From: Karl Roberts <Karl.Roberts@arun.gov.uk>
Sent: 06 September 2019 09:51
To: Joney Ramirez <joney.ramirez@rpsgroup.com>
Subject: Application A/100/19/PL - Arundel Acre, Angmering

Visibility Primary Direction (North)

1711056-SK01

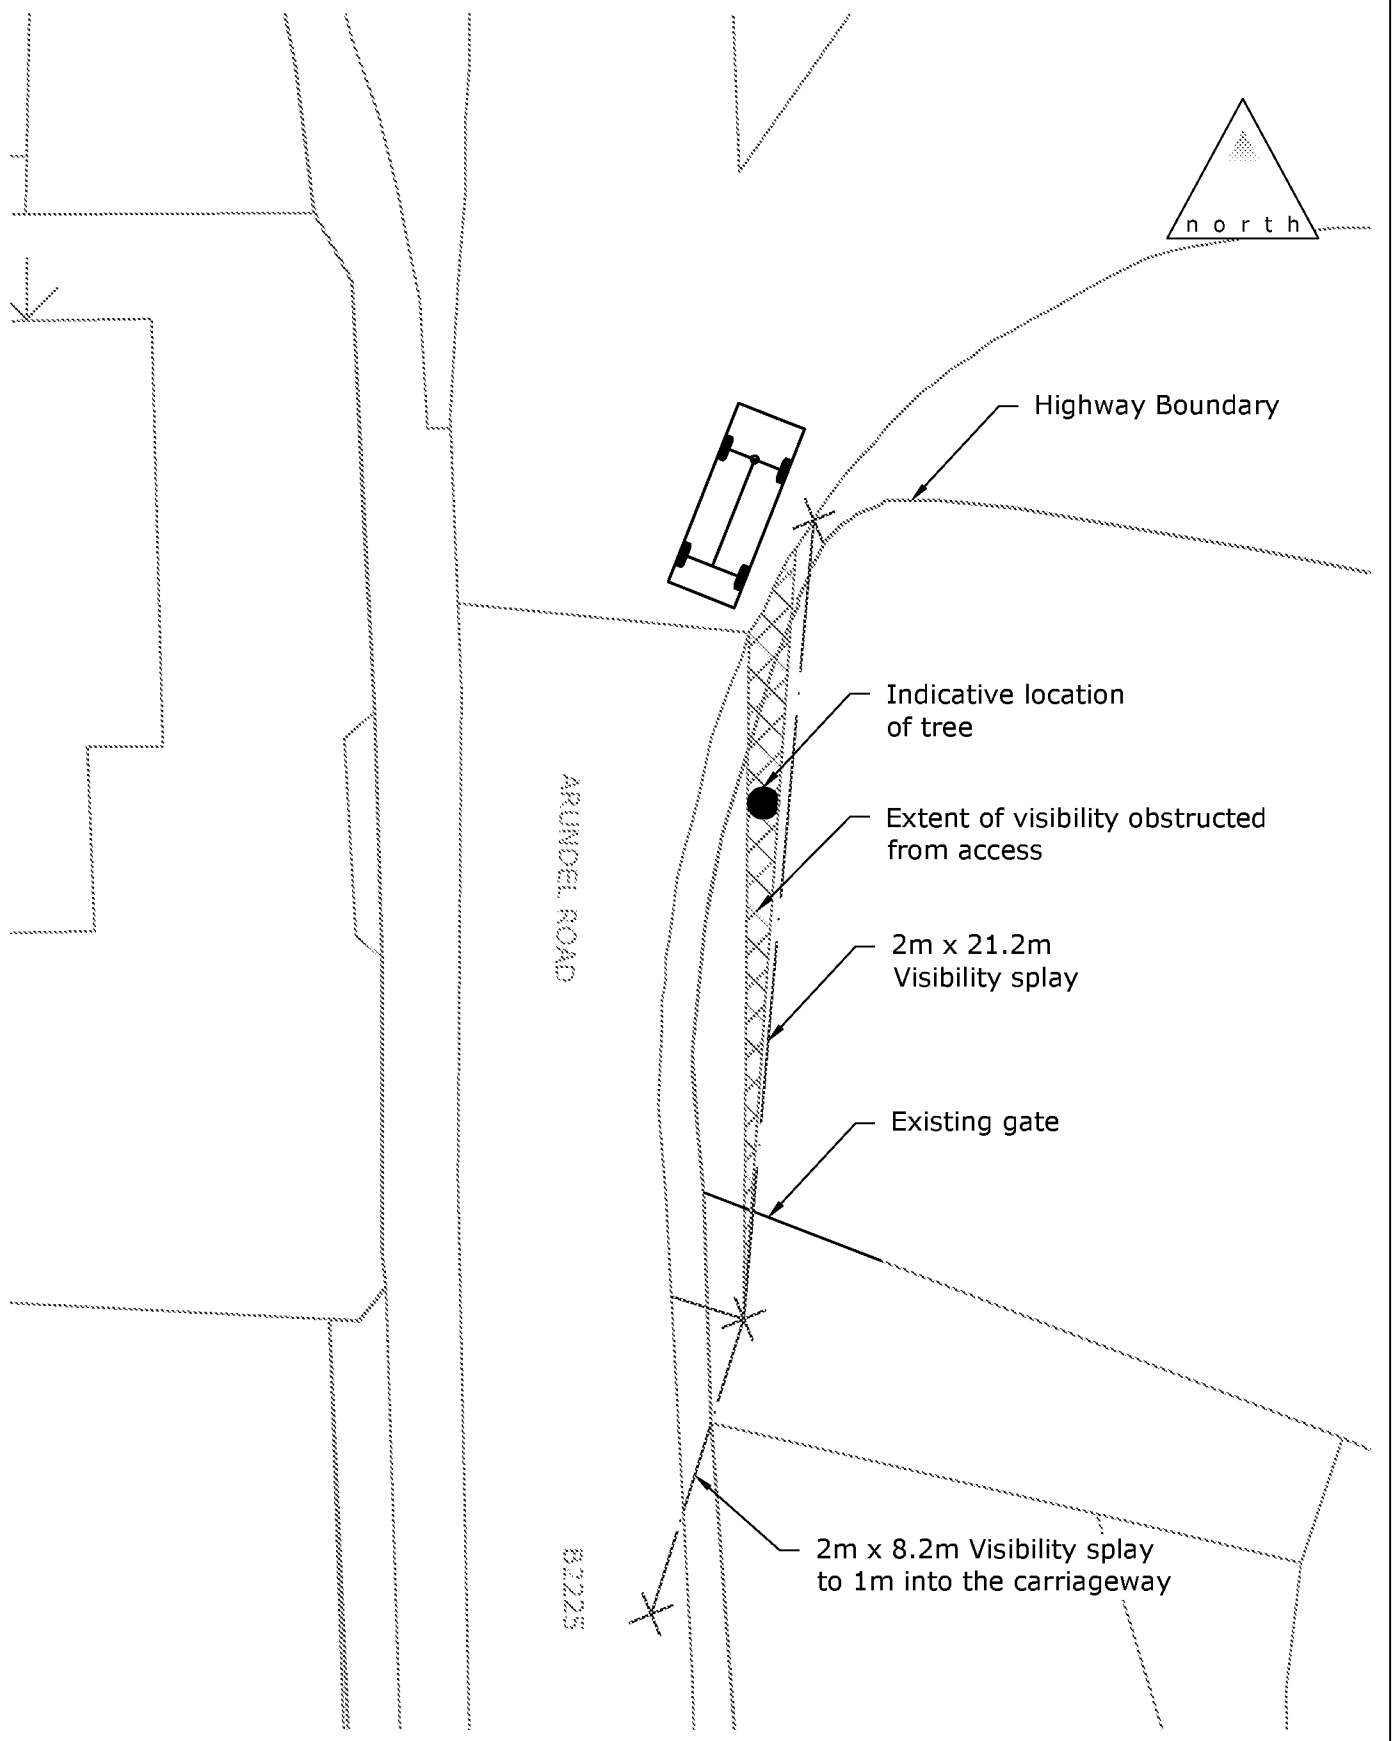
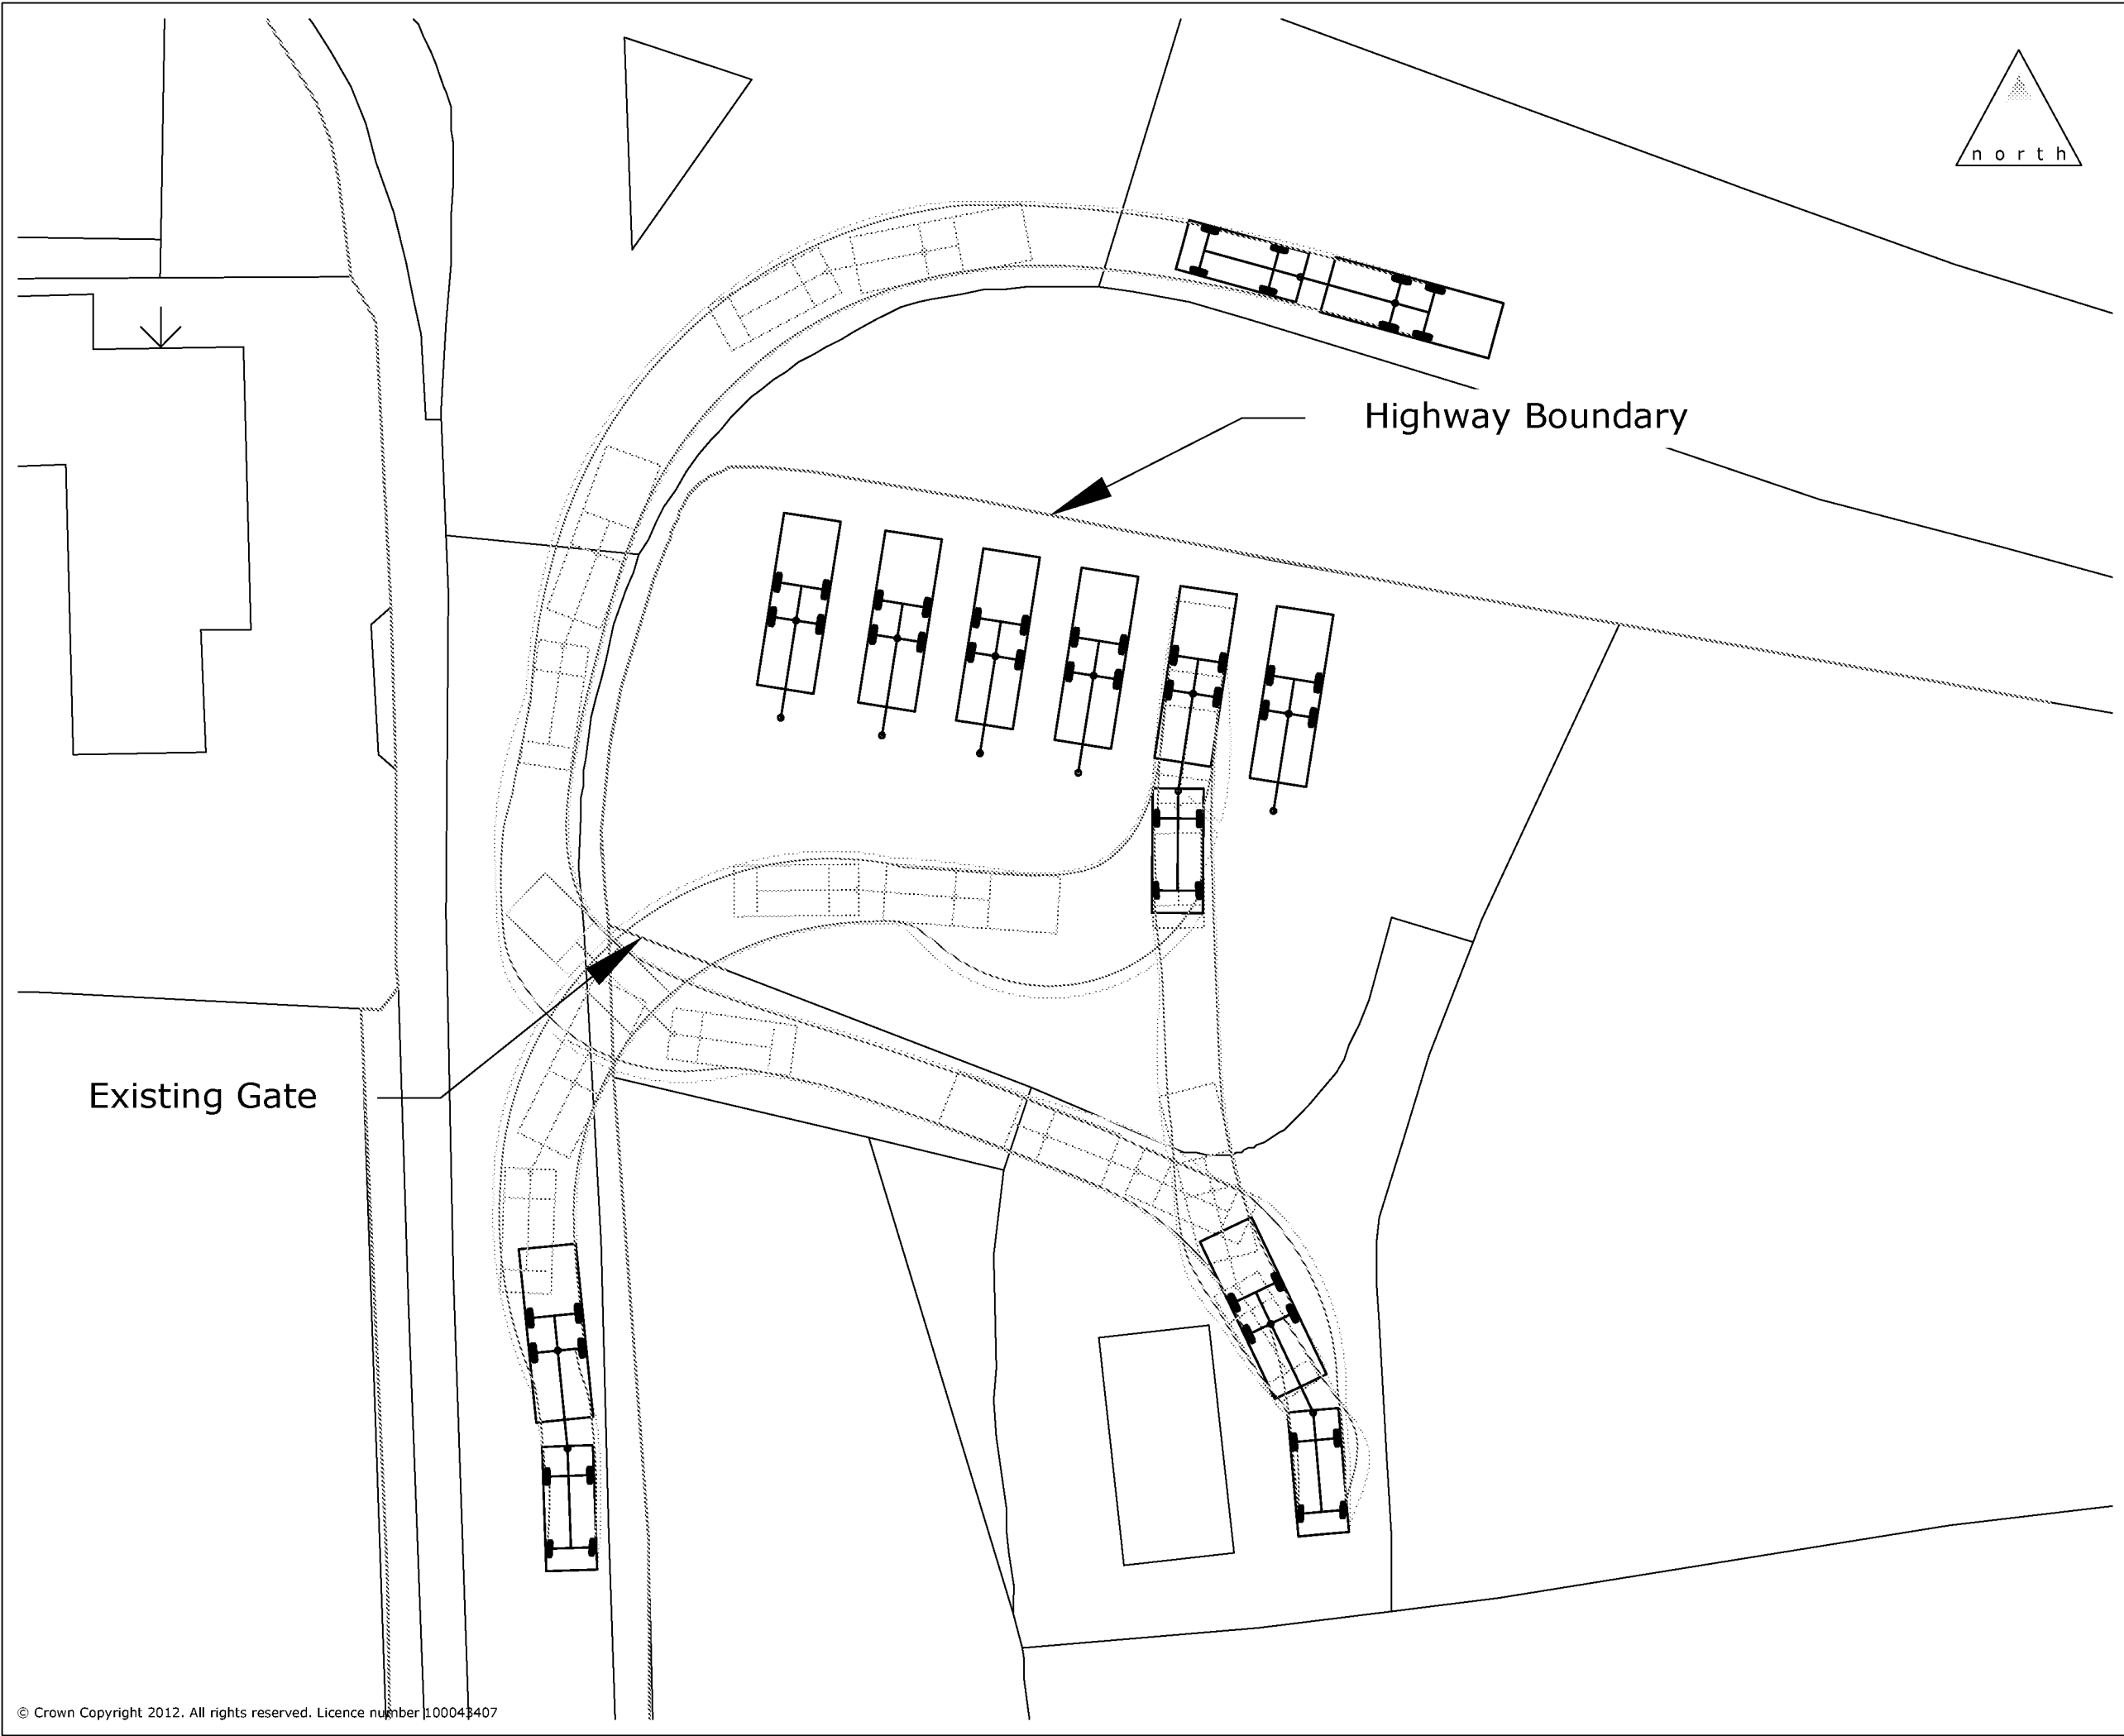
The application has not been supported with a revised Transport Statement nor does the current application seek to implement the improvement works relating to visibility north out of the access point.

As per A/3/18/PL it was accepted that a visibility splay of 2.4 x 21 metres is achievable and would be considered an improvement against the existing situation, where visibility is extremely limited.

The LHA is satisfied that such a condition could be imposed to secure such an improvement, however the Local Planning Authority (LPA) would be advised that the formation of such a splay is going to have a significant impact upon the vegetation boundary in this location, and may require the removal a mature tree.

As previously assessed under A/111/17/PL & A/3/18/PL visibility in the trailing direction was extremely limited due to 3rd party land. The maximum available visibility was demonstrated as 2.0 x 8.2 metres, measured 1.0 metre into the carriageway. The LHA did not accept that a 2.0 metre 'X' distance should be used. Nevertheless this would only equate to the stopping sight distance of an approach speed of 7 mph as per Manual for Streets calculation coefficients.

No evidence, previously or as part of this application has been provided to demonstrate such visibility is suitable or that any significant improvements could be made.

RPS Drawing/Figure Number	Rev
JNY10317/01a	-

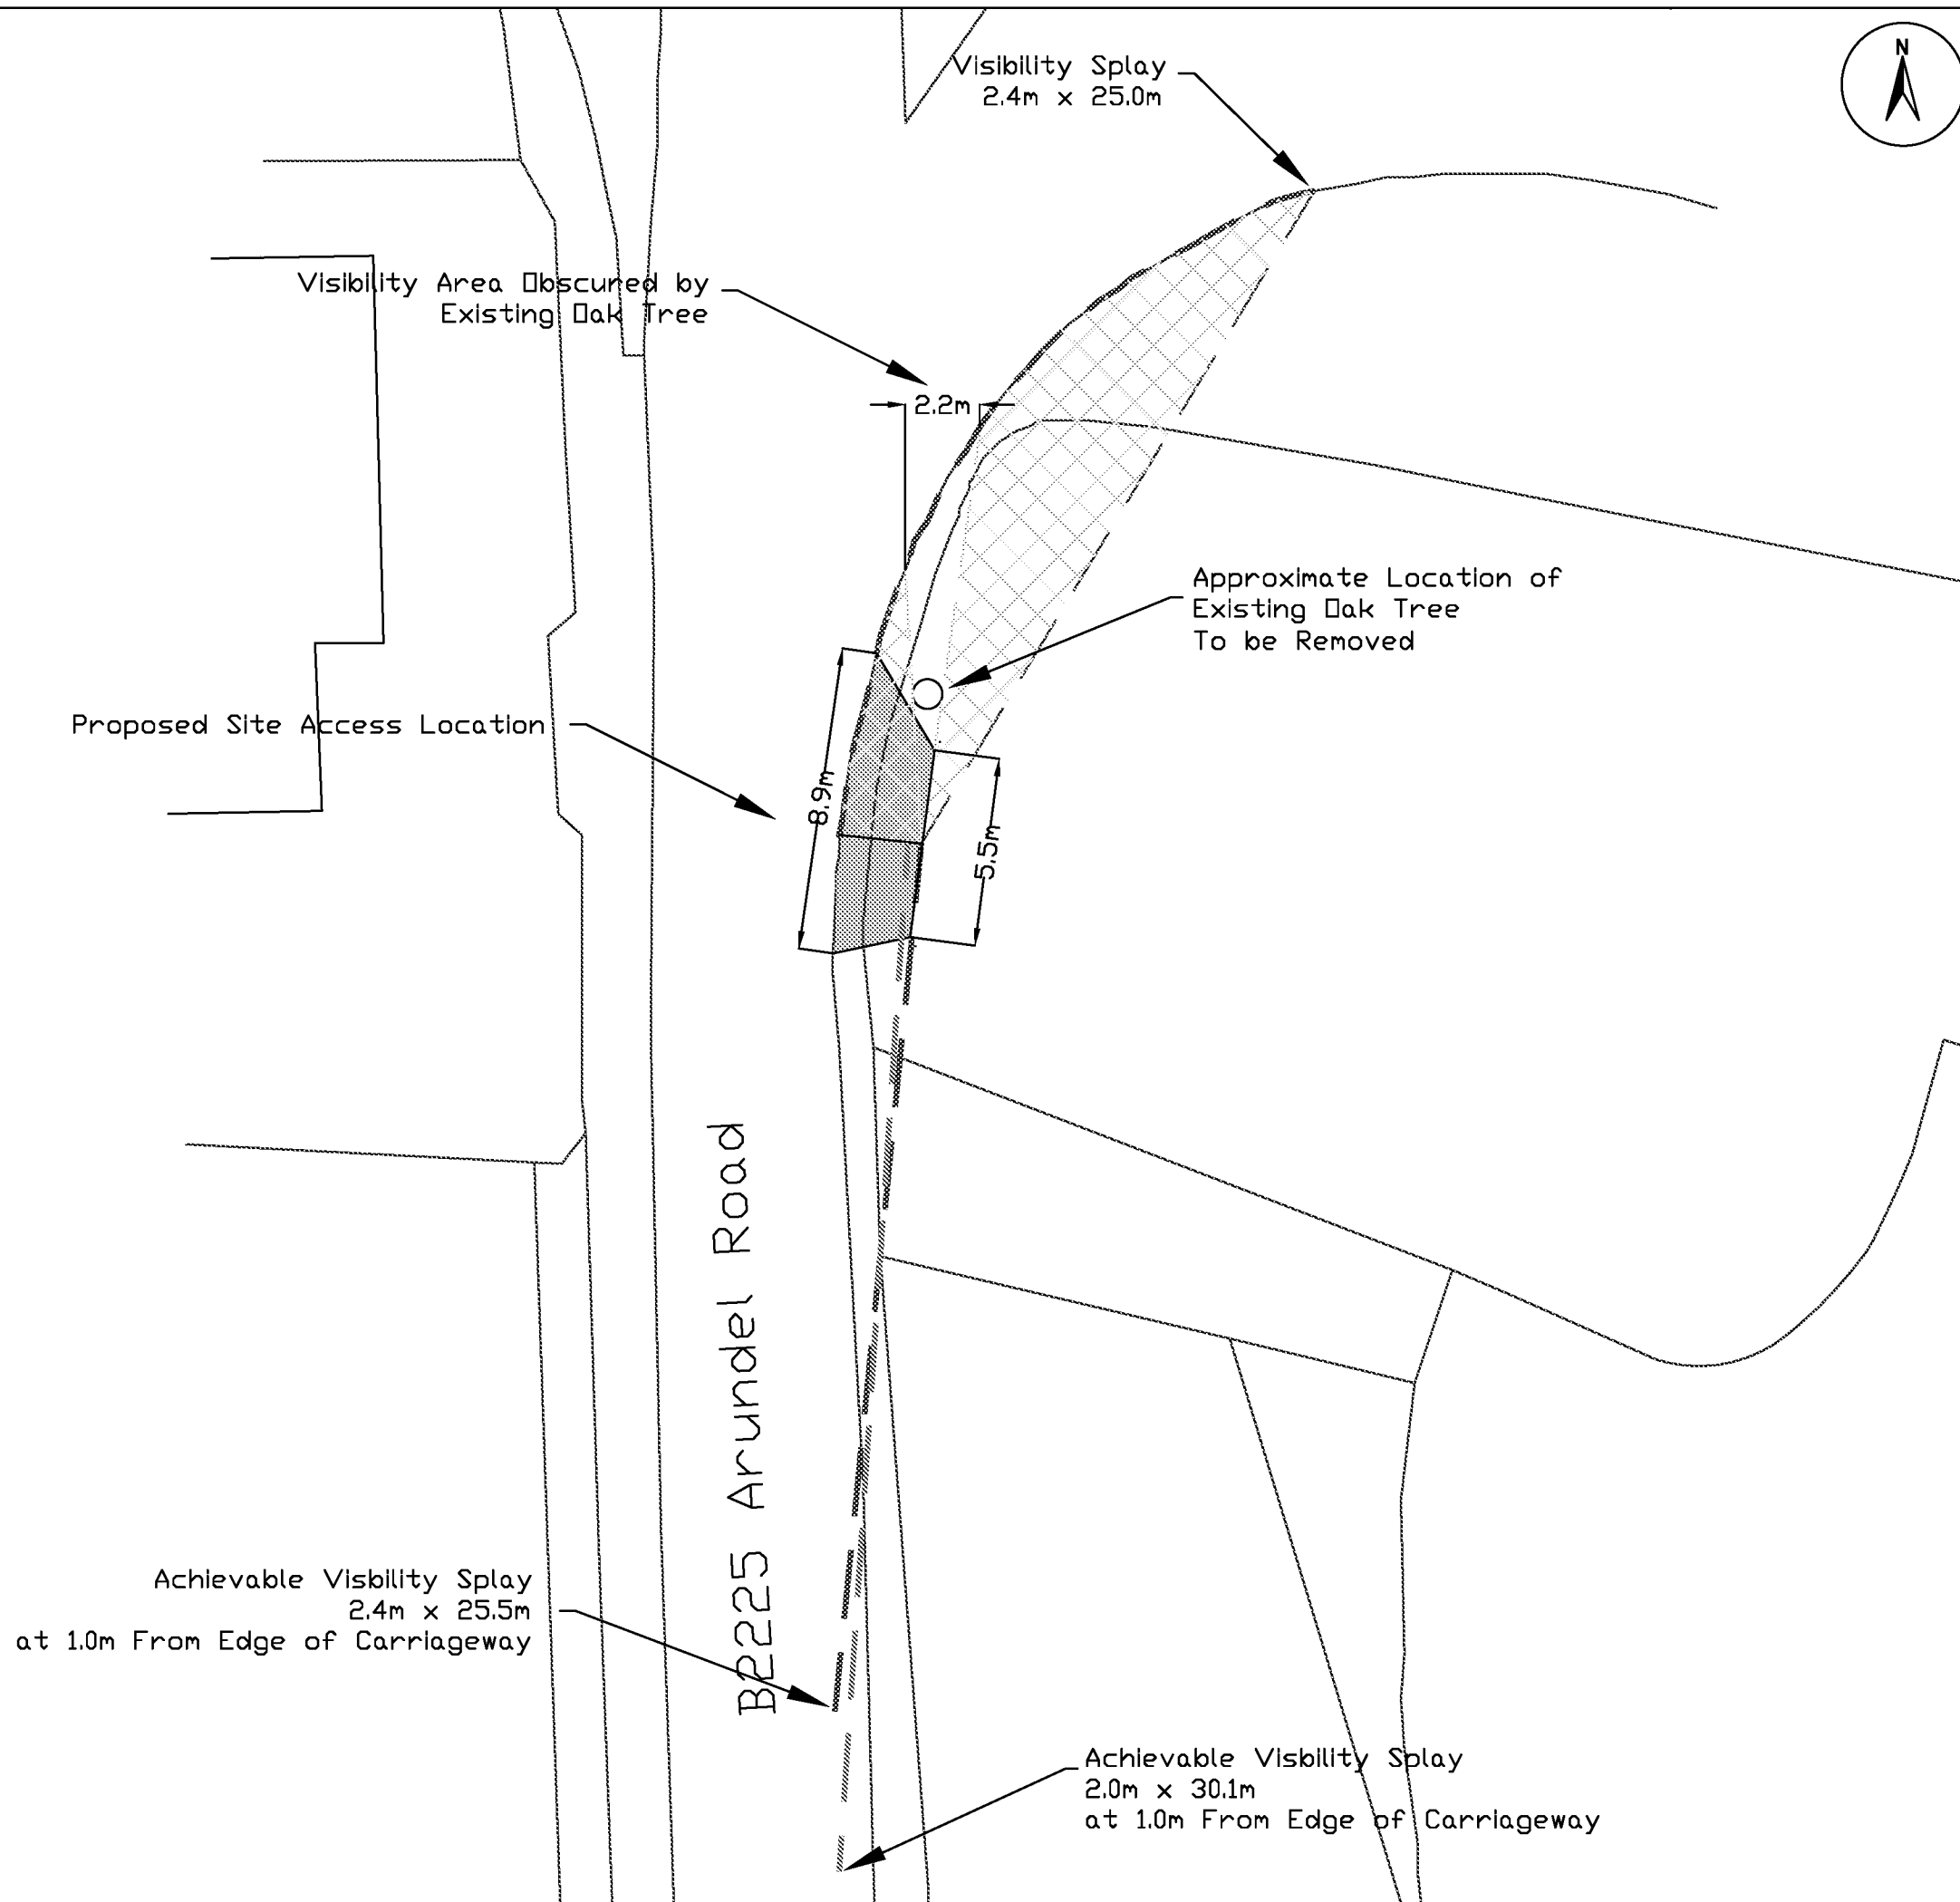
Thank you for the e-mail, the comments are noted. Could I ask that the plan showing the revised access be submitted separately from the report to which it is currently attached and it be amended to show the tree being removed.

With a change in the point of the access I believe it would be appropriate to re-advertise the application and reconsult. Before doing so do you wish provide any arboricultural statement regarding the position of the access in relation to the tree and the hardstanding behind. I would be grateful if you could advise by the end of the week whether it is your intention to do and if so how long you would need to submit a statement.

Please see attached the revised plan noting that for information purposes the tree is still showing, however a note has been included to show this tree to be removed.

You will note in Appendix B that we propose to move the access point of the site circa 9m to the north to achieve a significant improvement on the visibility splay to the south towards Arundel Road, without compromising the visibility from the A27. Appendices C and D provide information on the automated traffic counts carried out for vehicles coming from the south, and vehicle tracking diagrams to evidence vehicles will be able to turn and exit in forward gear. These address concerns and queries raised by SCC and Highways England. We would welcome any comments from these consultees.
